Portishead Branch Line (MetroWest Phase 1)

Planning Inspectorate Reference: TR040011

9.3.1 ExA.SoCG-NSC.D1.V1 – Statement of Common Ground

Date: November 2020

Drawing
PORTISHEAD STATION CAR PARK
LAYOUT, LANDSCAPING AND NEW
BOULEVARD AND ACCESS PLAN
SHEET 2 OF 3

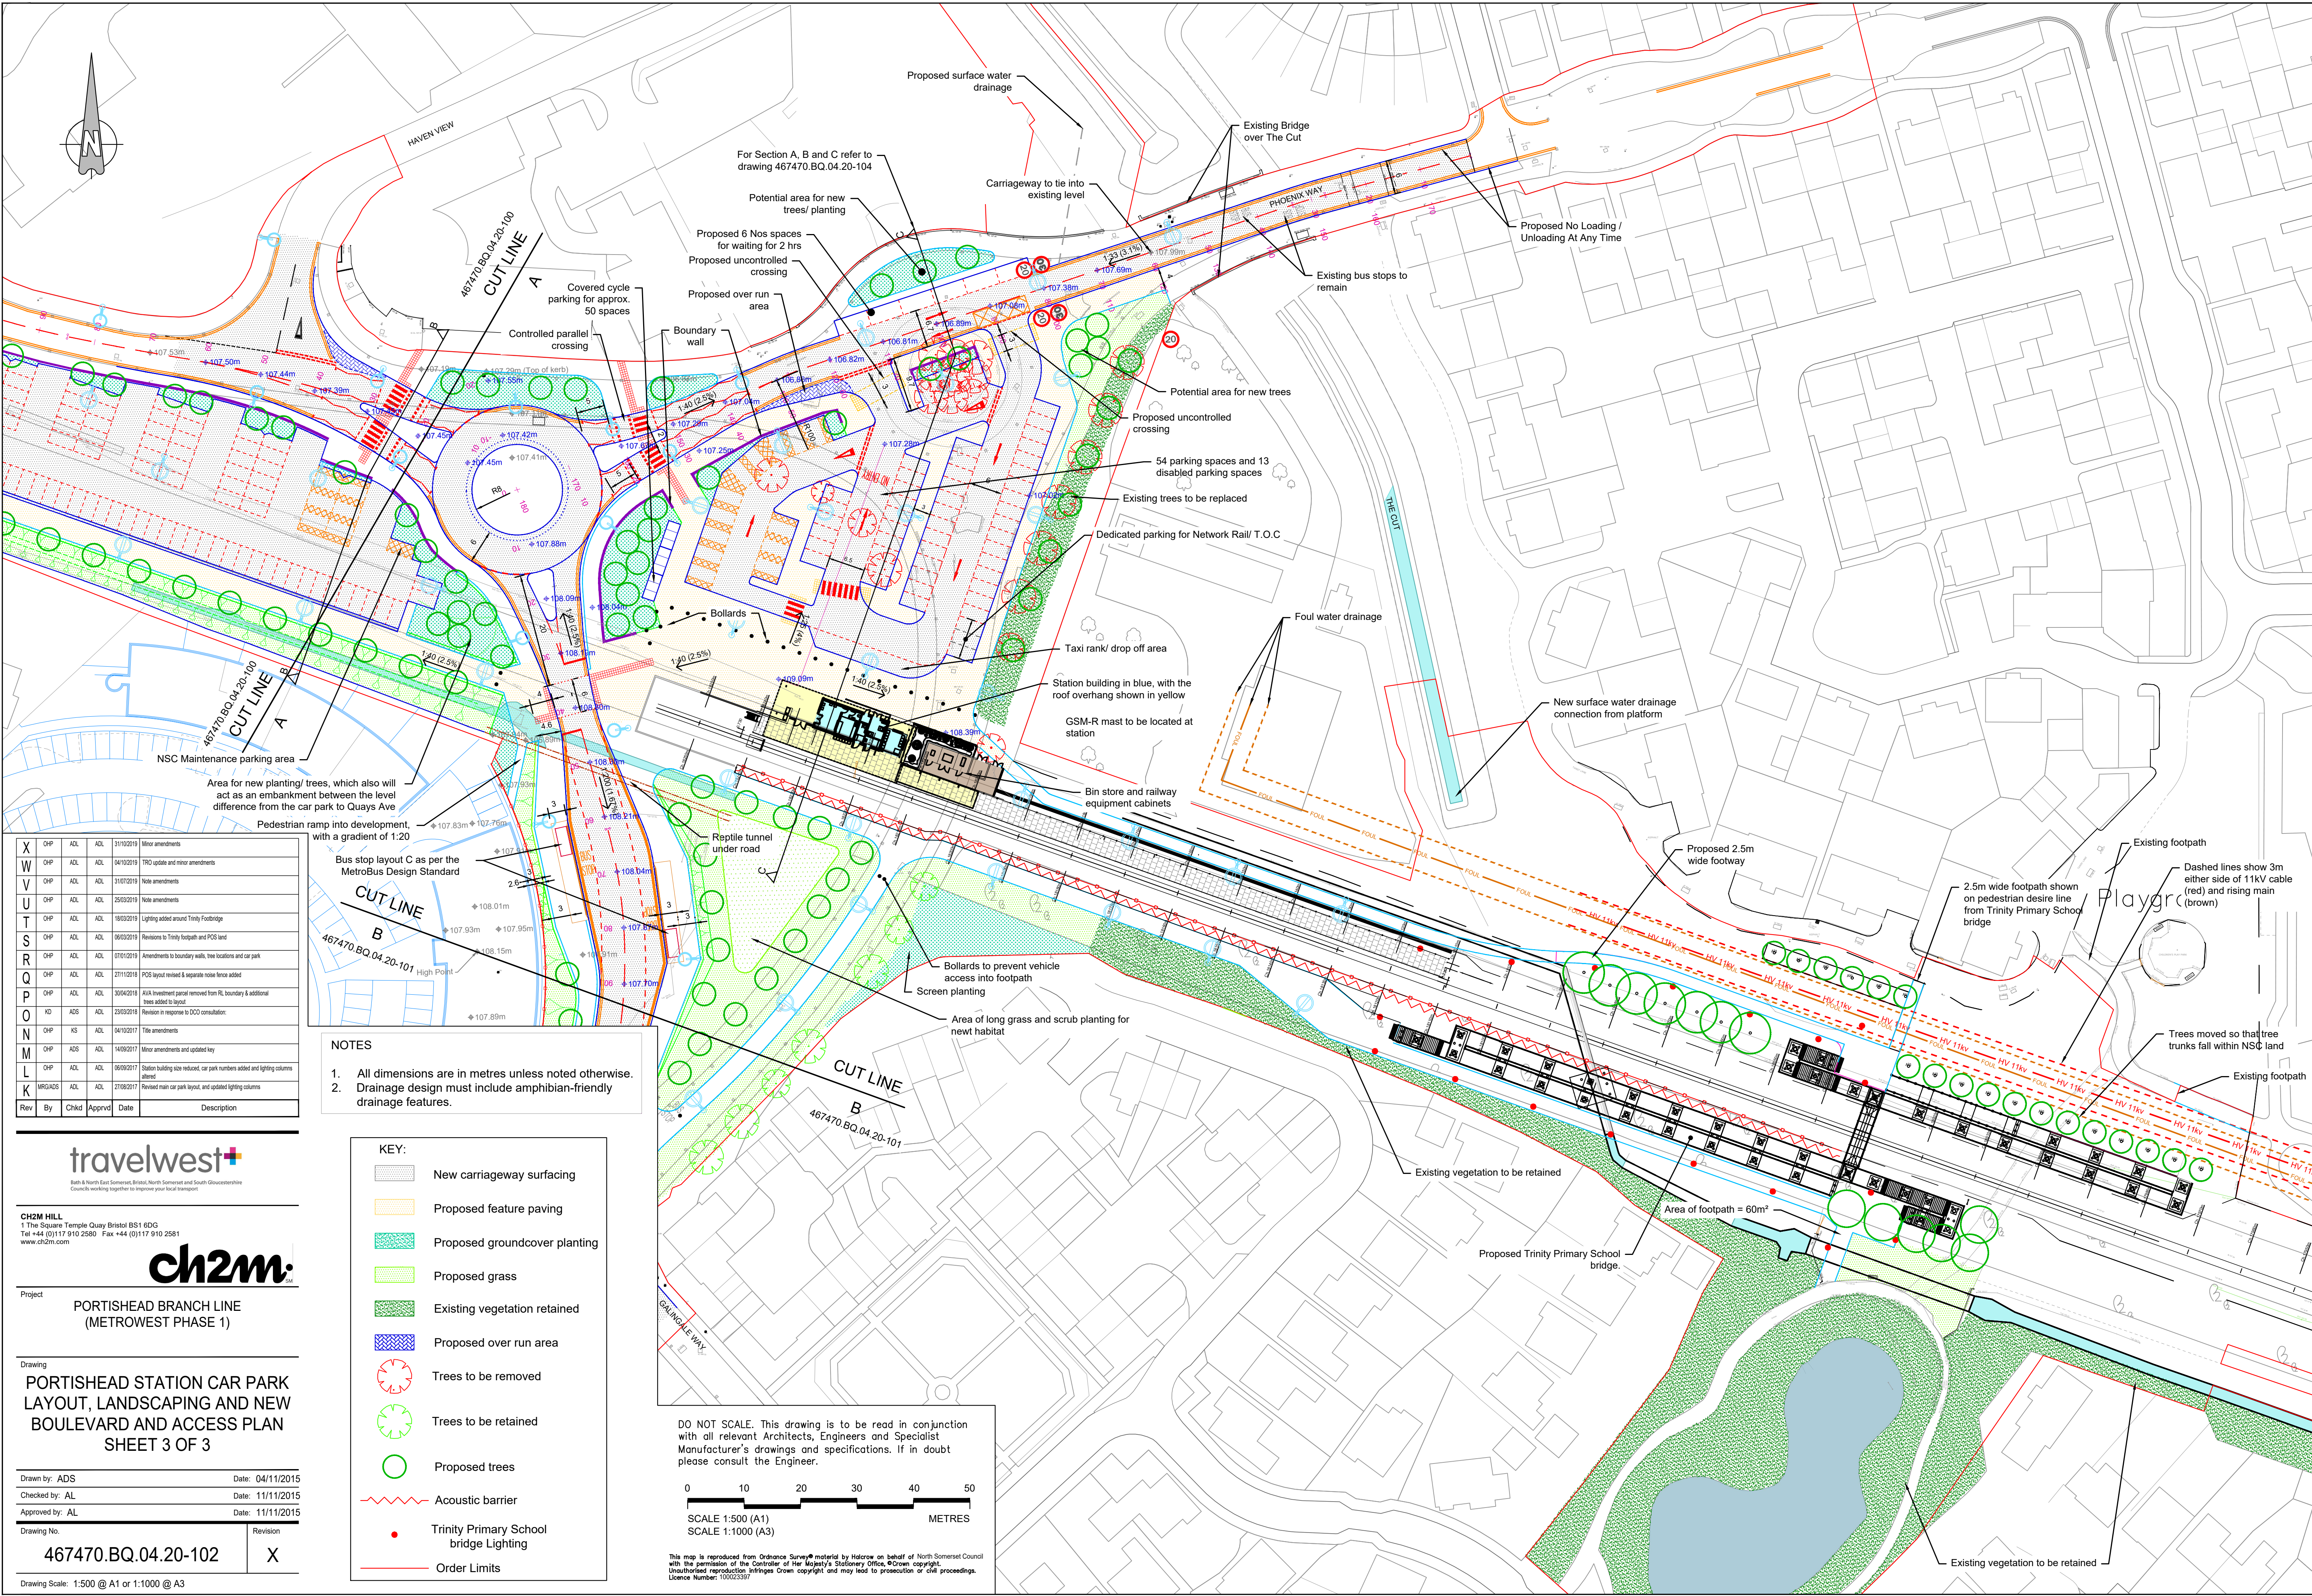
- (b) Requested further detail on how the larger car park access at the junction with Harbour Road and Papermill Gardens will operate. The proposed operation of this junction will need to be tested to demonstrate that it will operate satisfactorily;

2.42 - Pill Station Car Park and PSP Layout, Landscaping Lighting and Access Plan

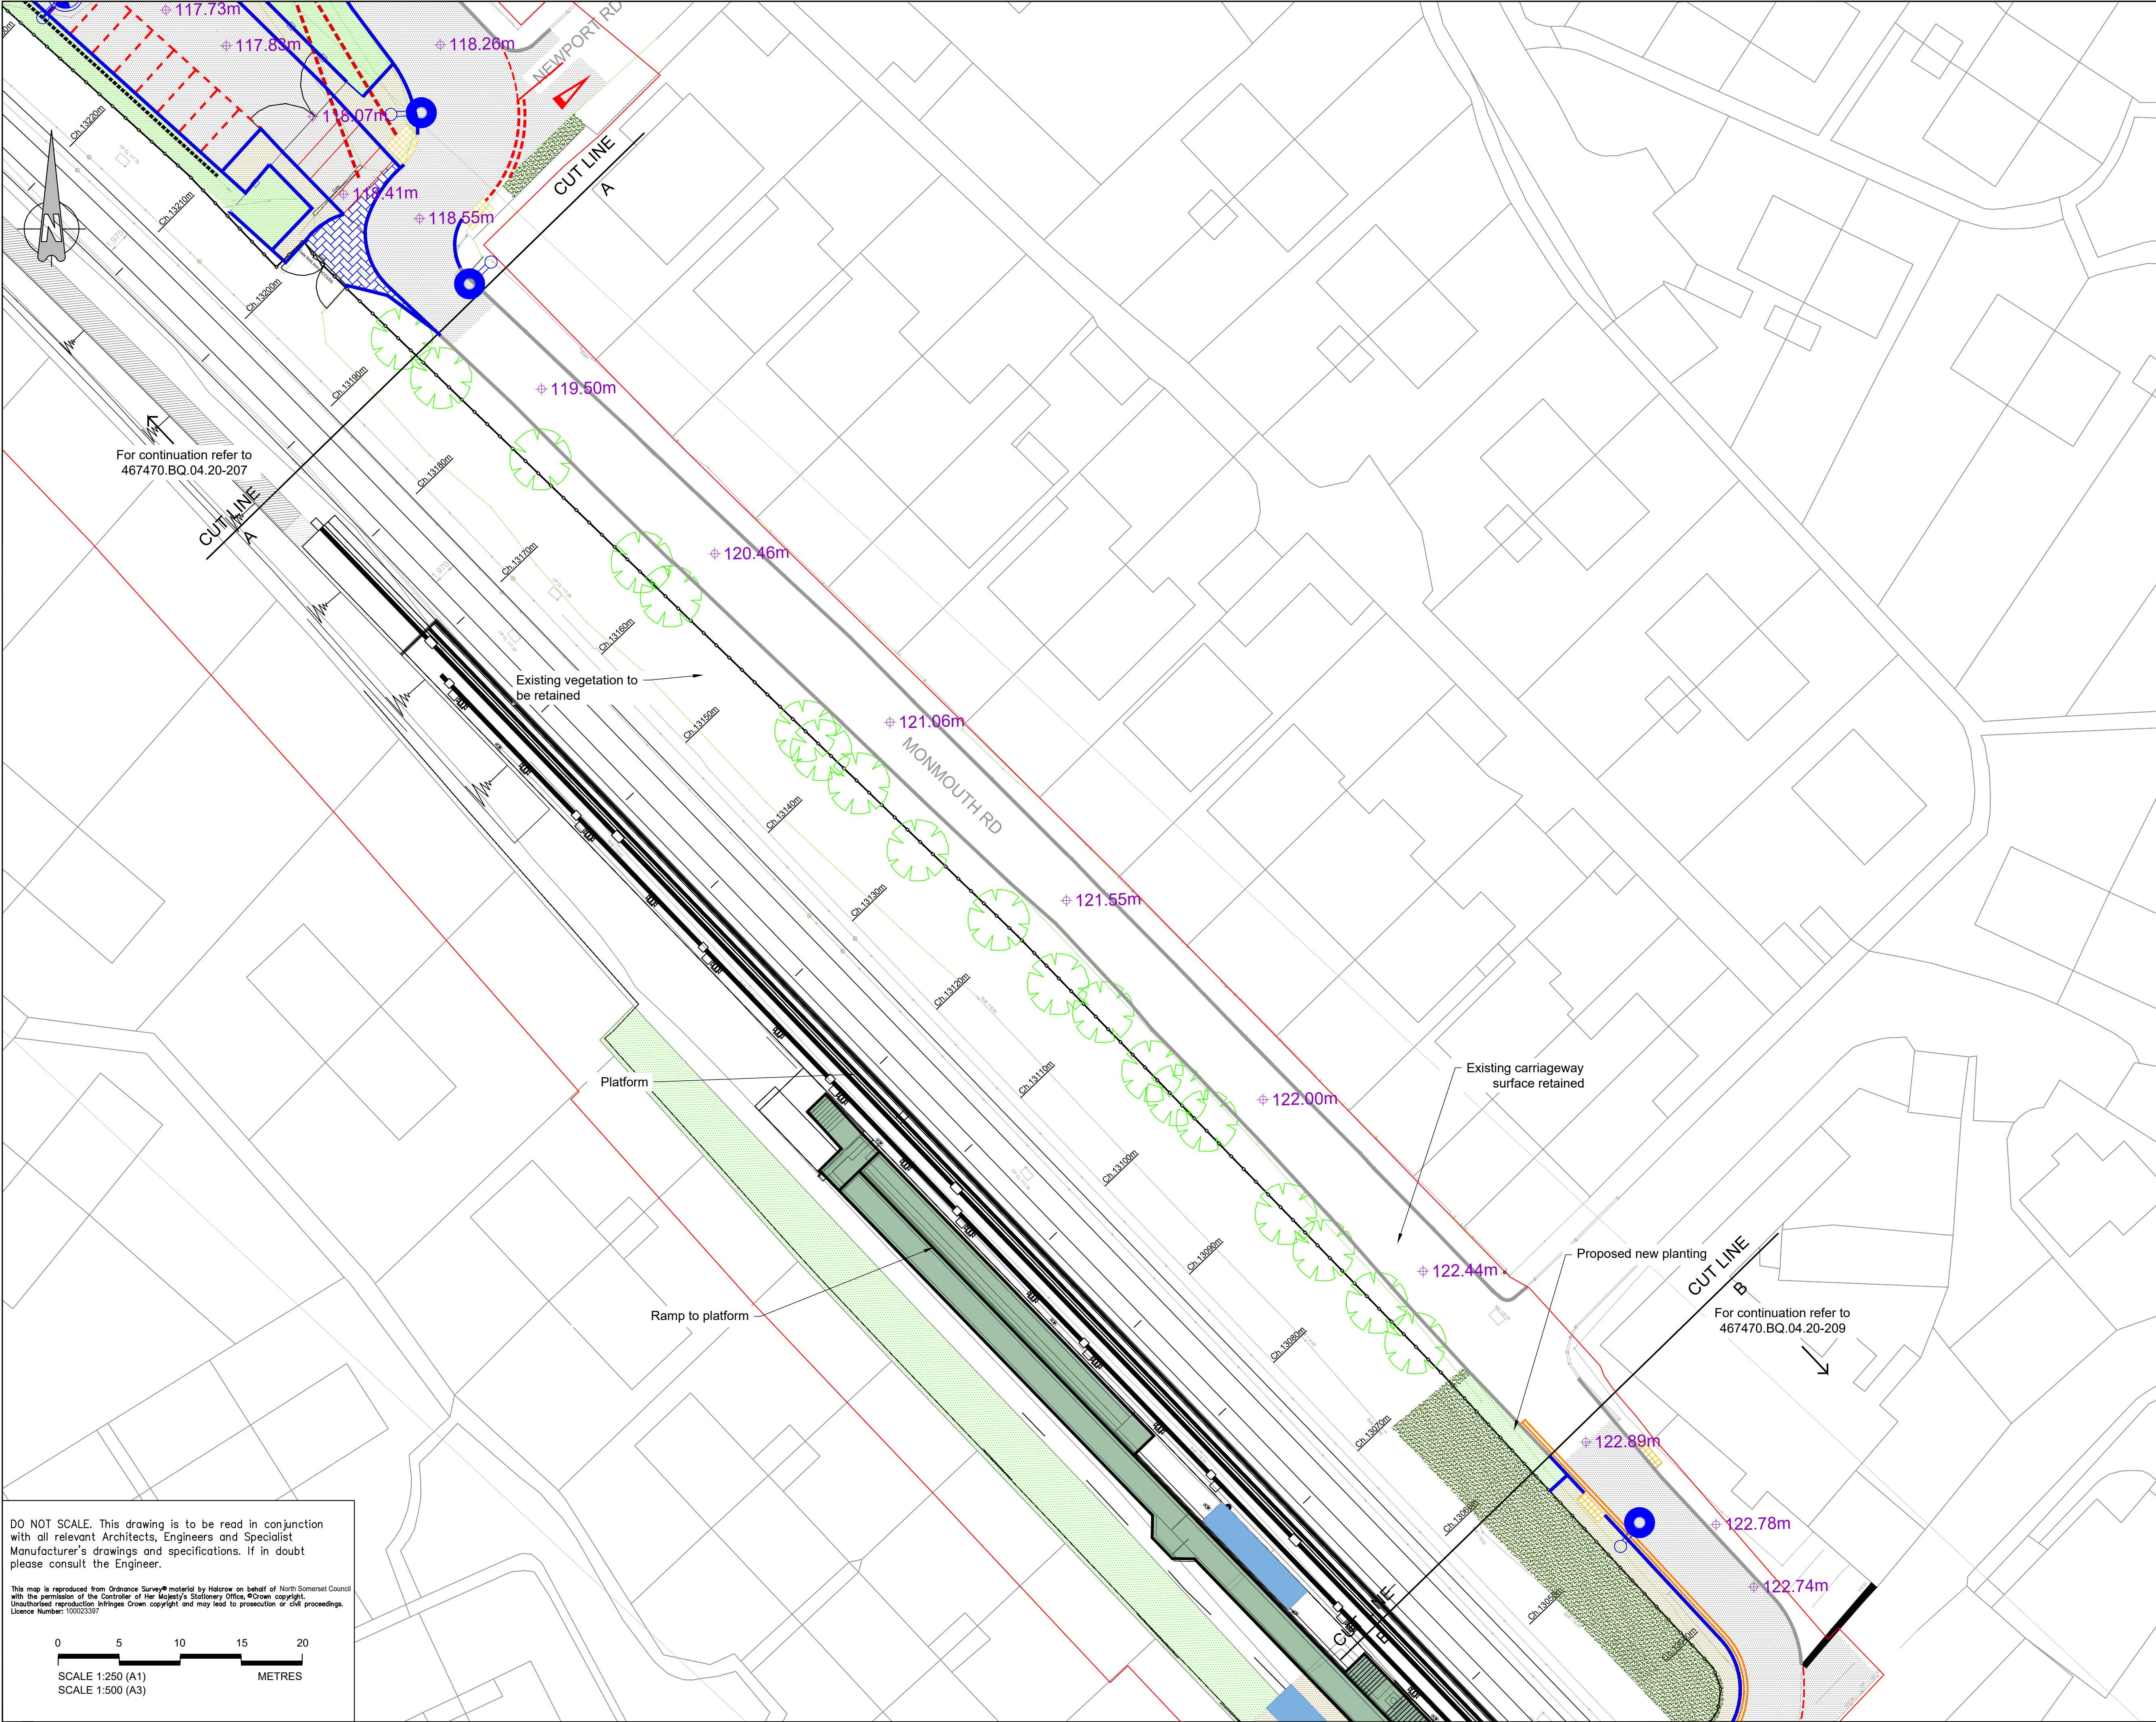
Ref.	Topic	LPA position	Applicant position	Status (Agreed/ Not Agreed)
8.1.1	Pill Station – design (Consultation)	The finish on the vertical wall at Pill Station could have texturing to it rather than be smooth concrete.	It was agreed to engage further with the LPA at the detailed design stage.	Agreed. The LPA's preference is noted, and both parties agree points concerning detailed design will be addressed collaboratively post-DCO.

8.1.3	Pill Station – highway drainage (Consultation)	Request checks take place at Pill Station car park as there are existing problems with the highway drainage network in the area, particularly with tide lock, which will require a capacity check and improvement of the system to adoptable standards.	<p>The existing highway drainage system has been surveyed to check its condition and capacity as detailed in Section 6.6.6 of the Surface Water Drainage Strategy for Portishead and Pill Stations, Haul Roads and Compounds (APP-192). The highway drainage survey reports have been issued to the Local Highway Authority and the information used to develop a proposed outline design for the drainage of Pill Station. The Pill Station Drainage Report (issued to the Local Highway Authority in February 2020) sets out the proposed route, capacity, outfalls and flow rates.</p> <p>The proposed solution will be developed further at the detailed design stage and subject to approval from the LPA.</p>	<p>Agreed.</p> <p>The proposed approach is agreed and outline designs are being developed in accordance with this.</p> <p>Detailed designs (performance modelling, implementation and maintenance details), will need to be submitted and approved by the LPA as set out in Requirement 11 of the dDCO (APP – 052).</p>
